Rezoning Transportation Analysis

Petition Number: 2020-088

General Location Identifier: Tax ID 02932106A

Date	Description
07-23-2020	First Review
09-22-2020	Second Review

OPTION 1A: PROSPERITY RIDGE ROAD EXTENSION SECTION WITH BICYCLE LANES (SHOWN WITH ON STREET PARKING WHERE APPLICABLE)

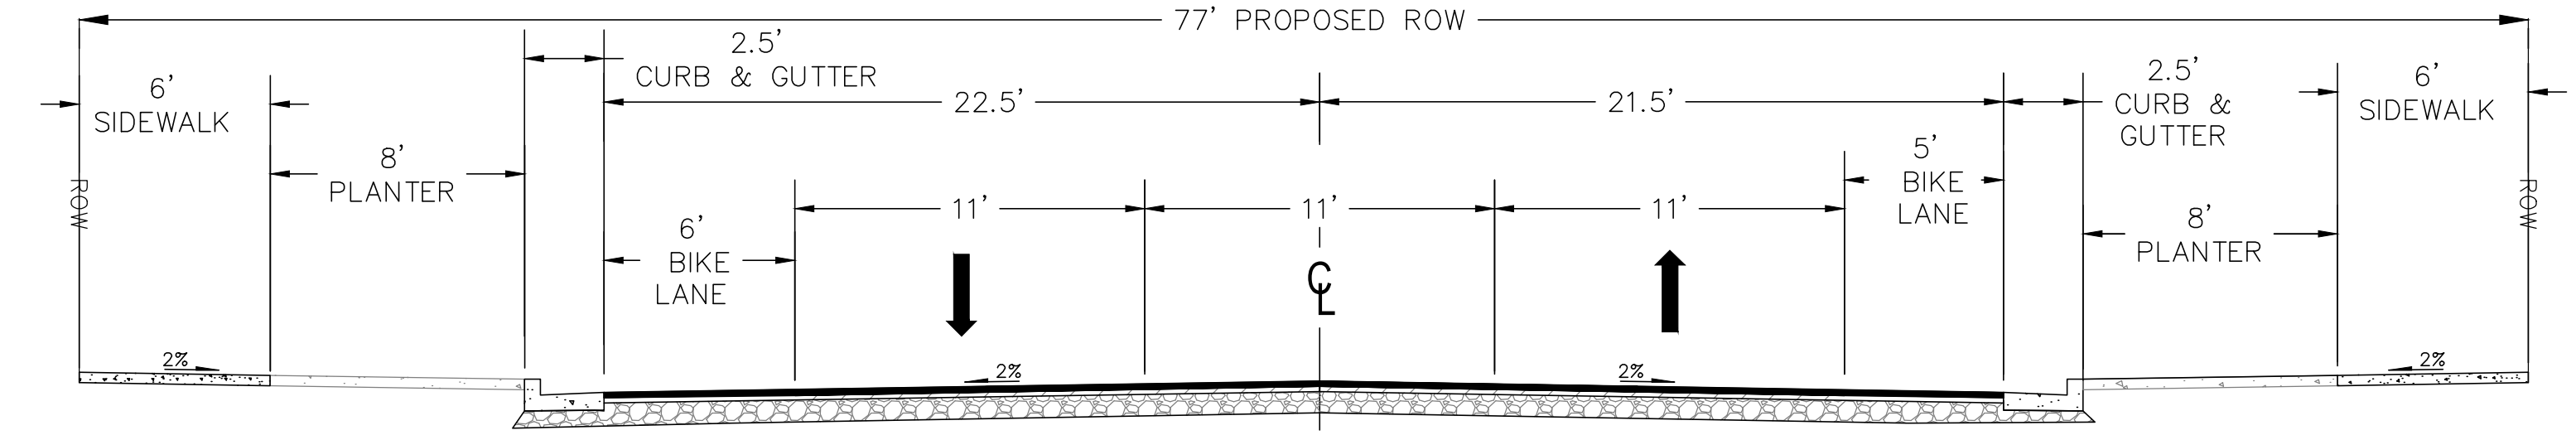
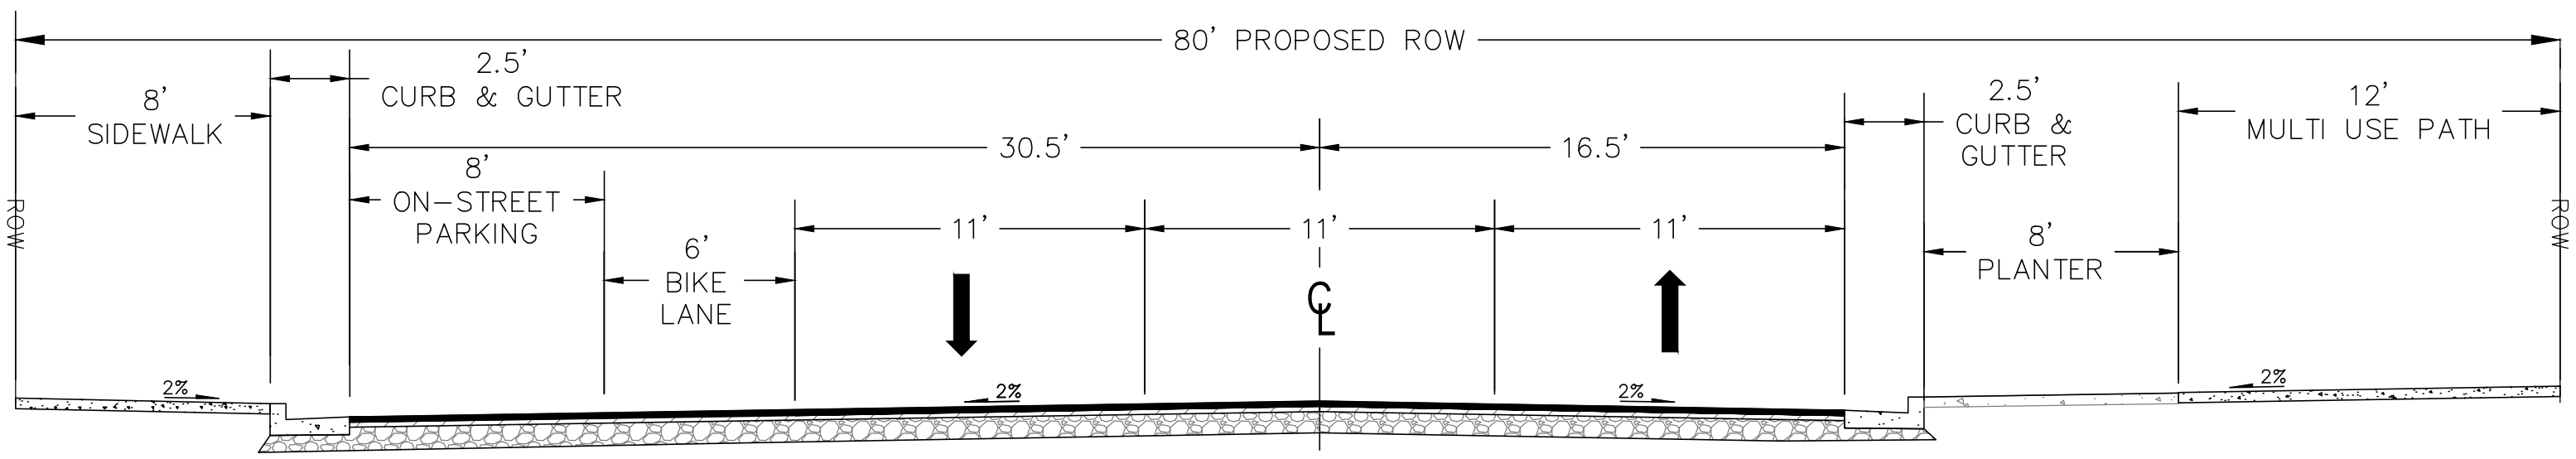
- Outstanding** Increase the width of the bike lanes to 5-ft, in accordance with Charlotte BIKES. The petitioner should revise the site plan and conditional note(s) to revise the Prosperity Ride Road Extension to replace the proposed 4-foot bike lane with a 5-foot bike lane. Please revise the proposed valley gutter shown to a 2.5-foot curb and gutter.
